**Our ref:** WA/2015/119522/01-L01  
**Your ref:** 14/02121/OUT  
**Date:** 2 February 2015

**Outline - development to provide up to 1,700 residential dwellings (class c3), a retirement village (class c2), flexible commercial floorspace (classes a1, a2, a3, a4, a5, b1 and c1), social and community facilities (class d1), land to accommodate one energy centre and land to accommodate one new primary school (up to 2fe) (class d1). Such development to include provision of strategic landscape, provision of new vehicular, cycle and pedestrian access routes, infrastructure and other operations (including demolition of farm buildings on Middleton Stoney Road).**

**Proposed Himley Village, North West Bicester, Middleton Stoney Road, Bicester, Oxfordshire.**

Figure 3.3 NW Bicester – Site Location Plan with Key Drainage Features

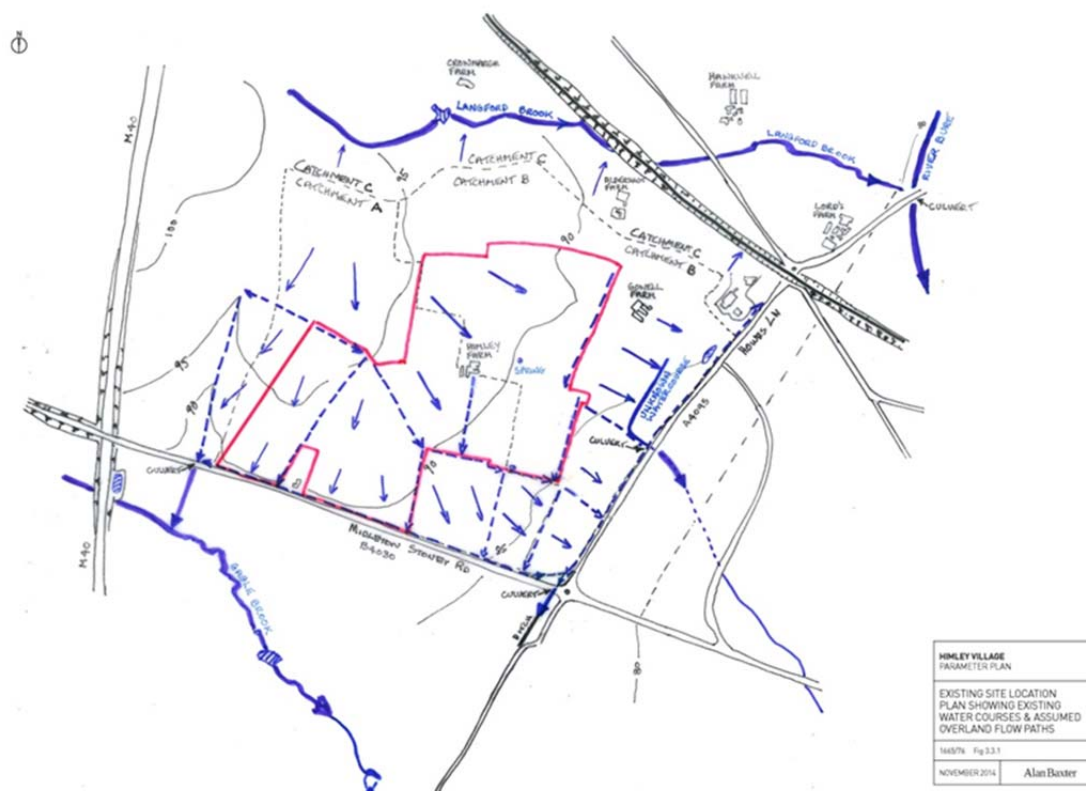
In particular, the submitted FRA fails to satisfactorily demonstrate that there are viable outfall locations for surface water discharging from the site. The FRA states that culverts under the A4095 and B4030 have been identified as probable points of discharge from the site to nearby watercourses, but states that the capacity, condition and ownership of these culverts is unknown. Prior to determination of this application we recommend further work is completed to confirm that surface water can be drained via these culverts.

Our objection can be overcome by submitting a FRA which covers the deficiencies highlighted above and demonstrates that the development will not increase risk elsewhere and where possible reduces flood risk overall. If this cannot be achieved we are likely to maintain our objection to the application.

Outline SuDS Parameter Plan

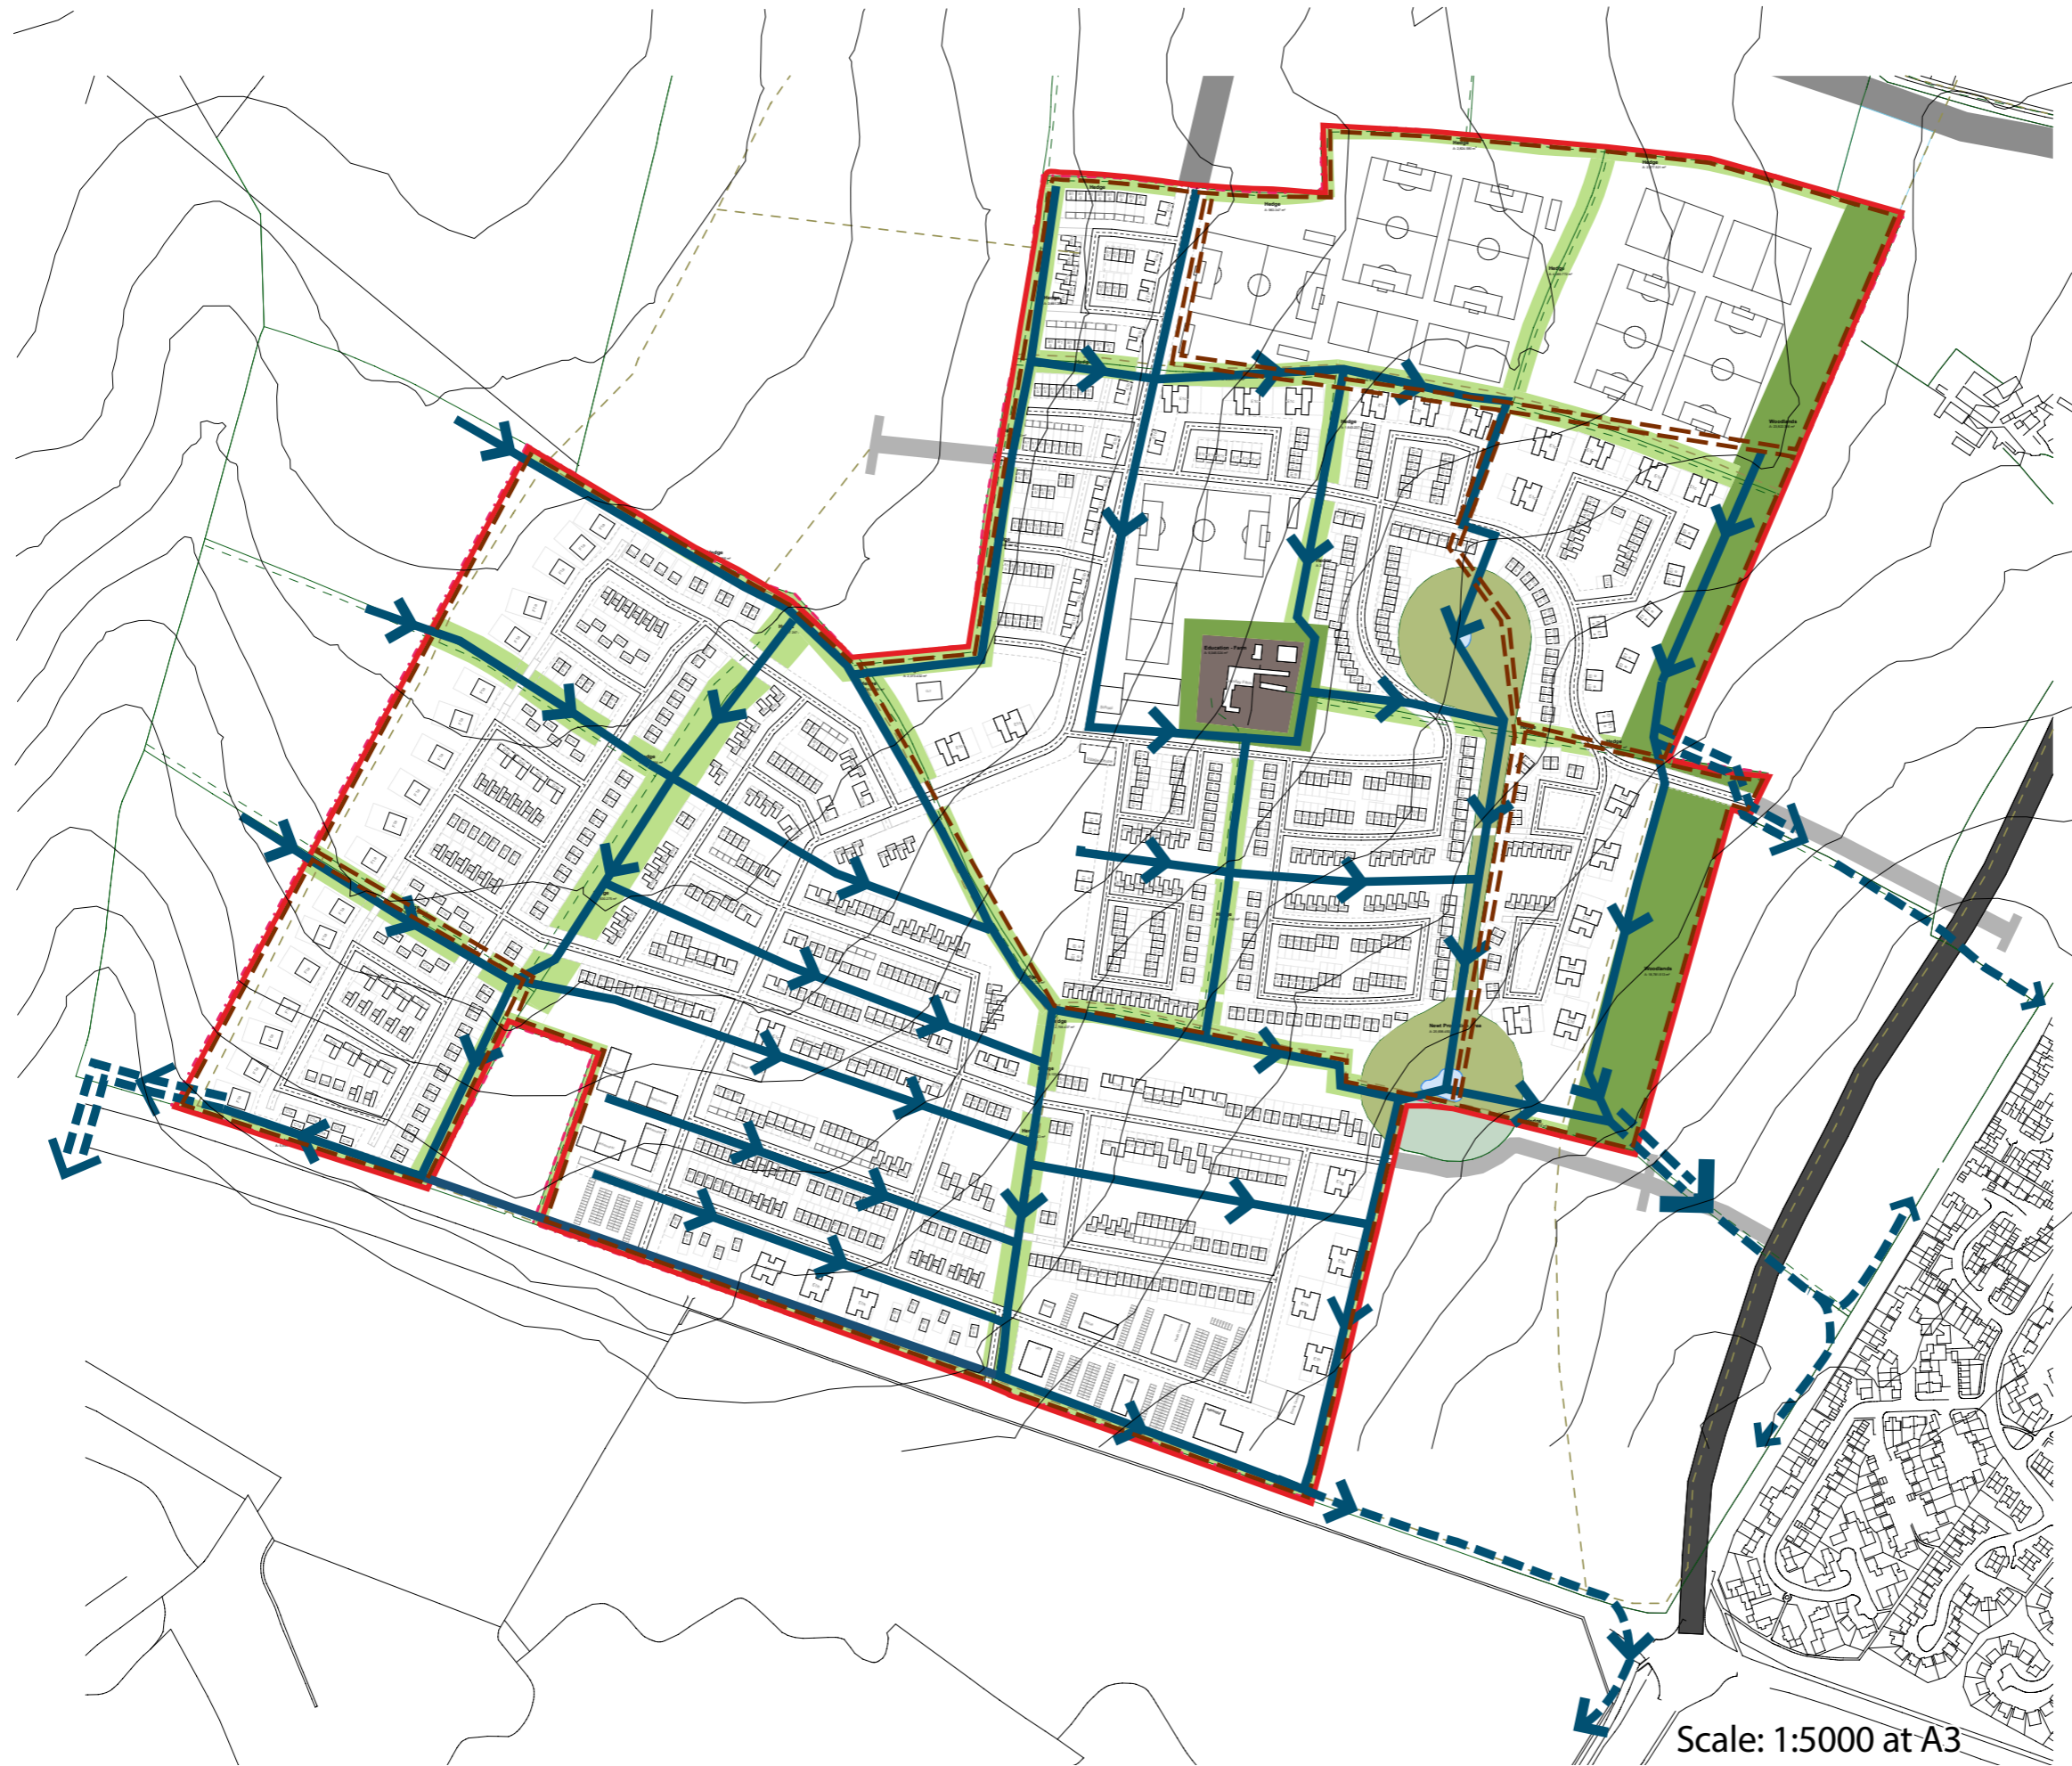
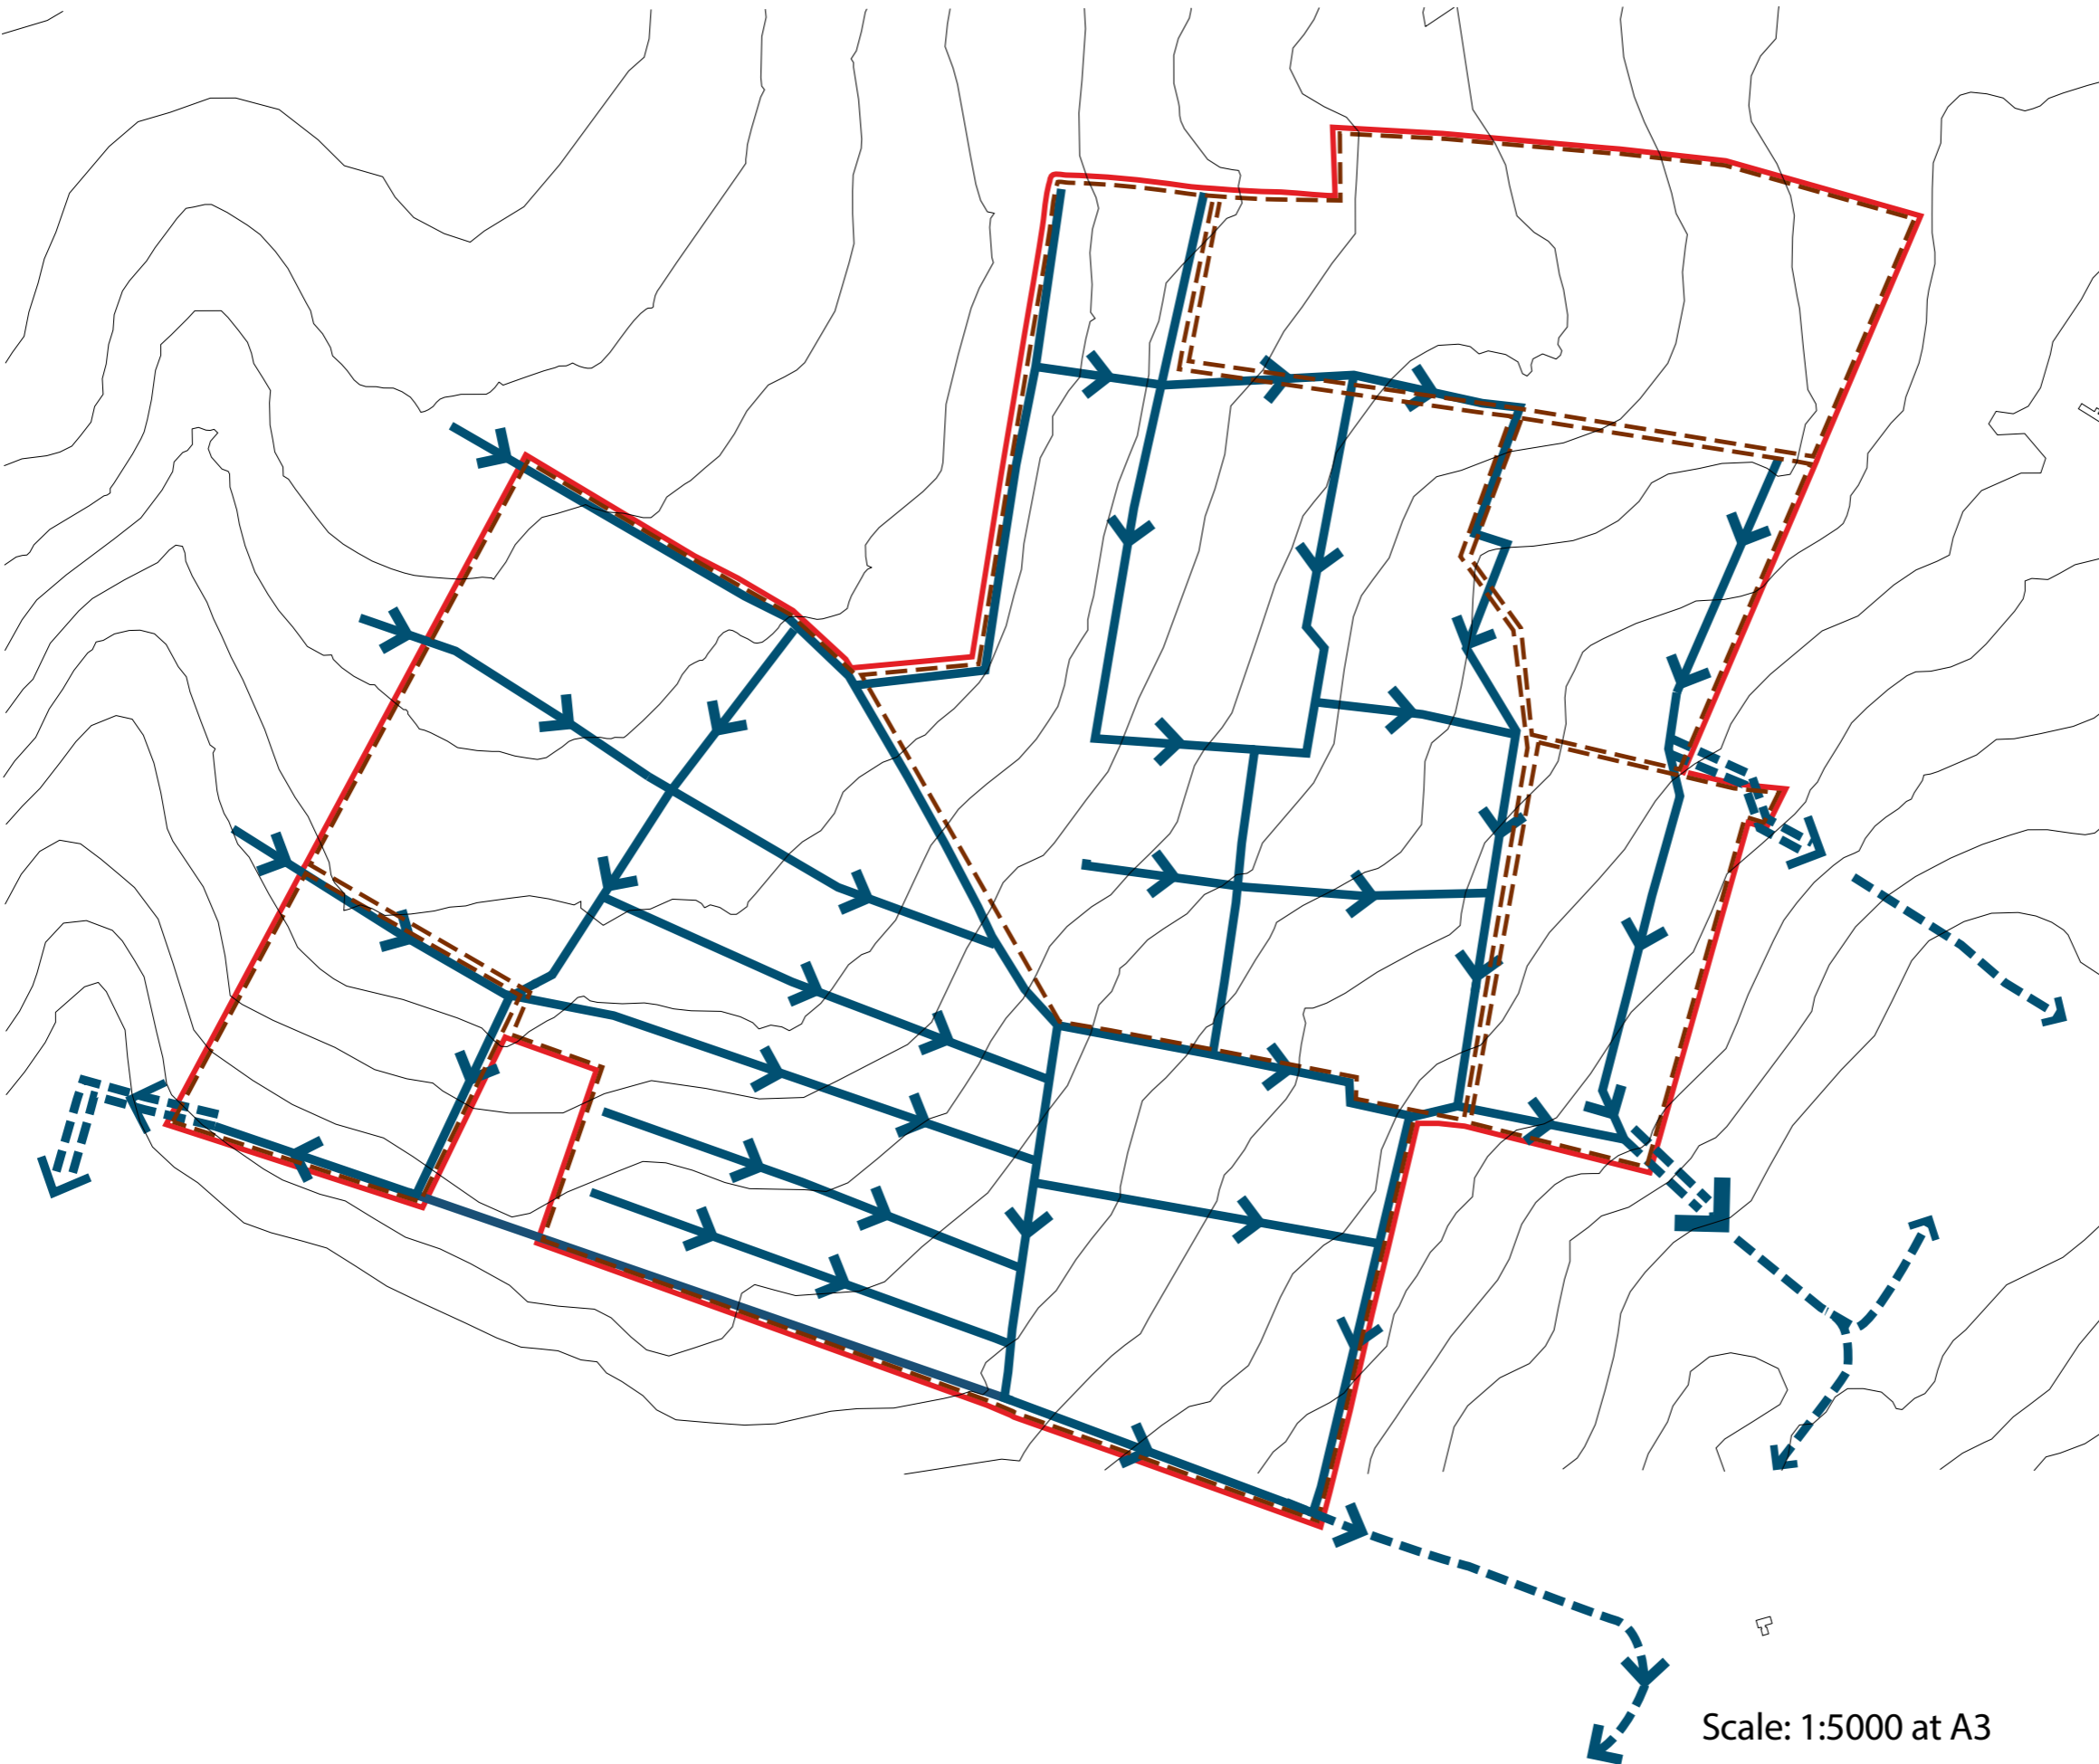
We also require further information to be provided on how and where the required 27,000m<sup>3</sup> of surface water attenuation will be provided on the site. We welcome the outline drainage strategy based around a network of swales and a range of other sustainable drainage techniques, including source control measures. However, it is not clear from the plans that sufficient storage is being provided within the indicative layout, especially during early phases of the development.
